Our Ref: A/48/18/HH
Your Ref:

Town & Country Planning Act 1990 (as amended)
Town & country Planning (Development Management Procedure) (England) Order 2015
Application for Planning Permission for Works or Extension to a Dwelling

Development Two storey side extension, replacement roof to include rooms in roofspace with 4 No. dormer windows to east & 1 No. dormer window to west.
Location 16 Garden Close Angmering

SITE PLANS

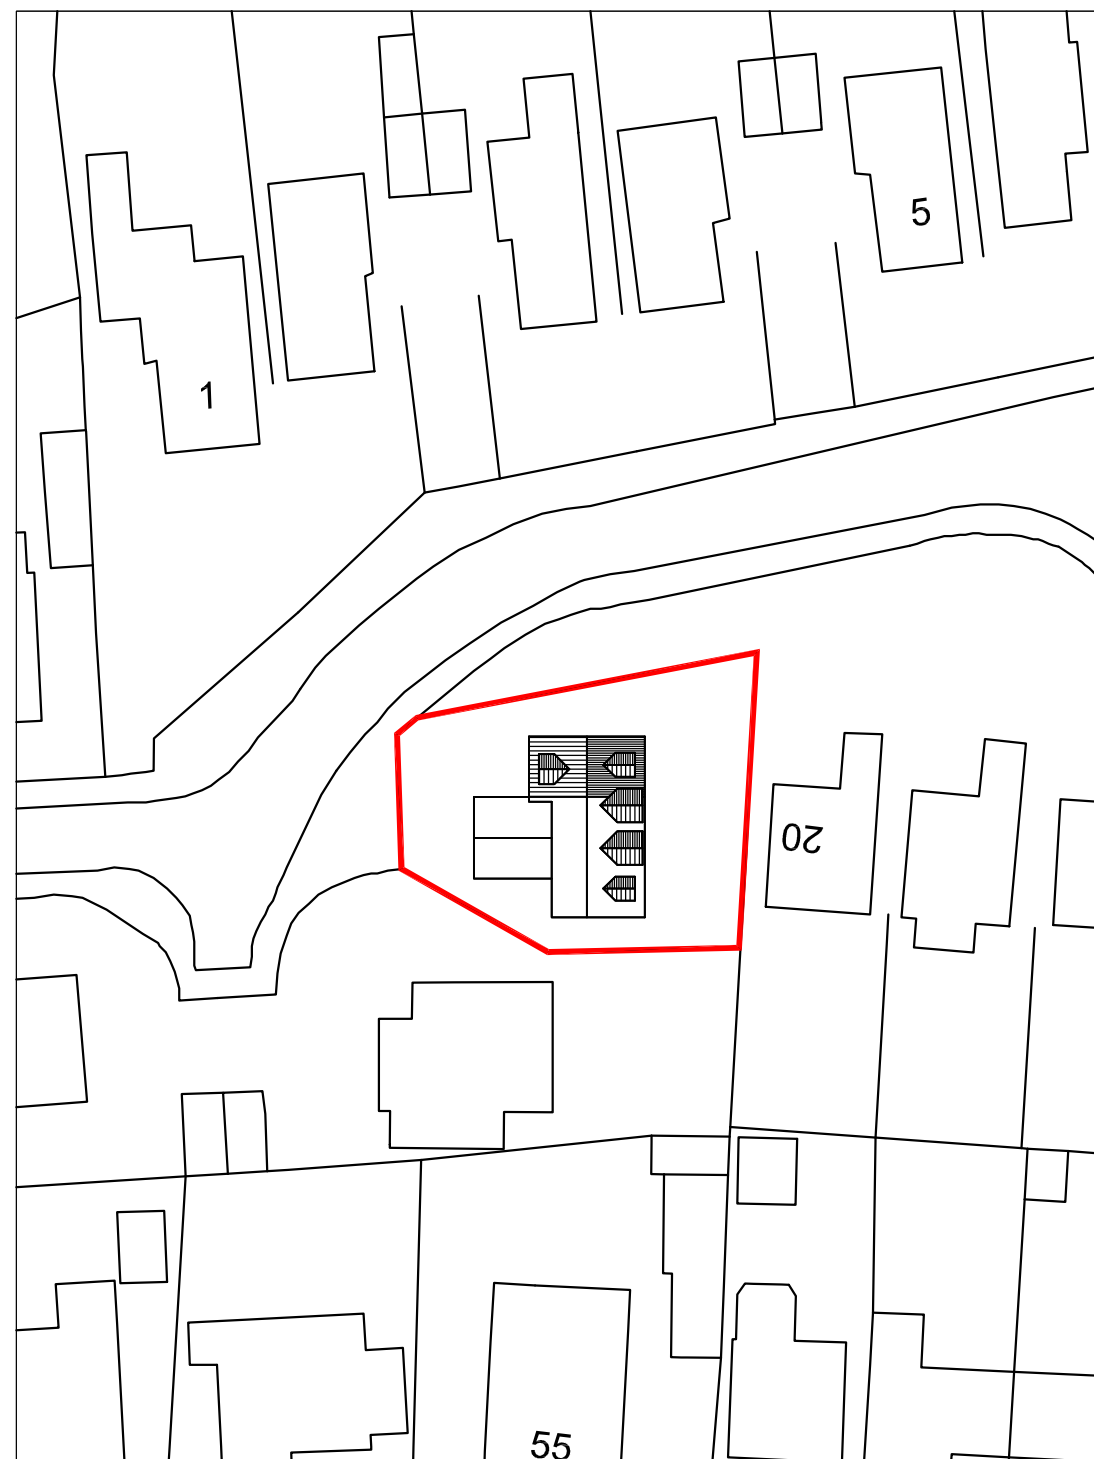
Block Plan Amend

Please submit 1 electronic or 3 paper copies of a block/site plan at a scale of 1:500 or 1:200. Further details of what must be included on the plan can be found in the National Validation Requirements. Please highlight the proposed works and provide measurements from the proposal to the site boundaries.
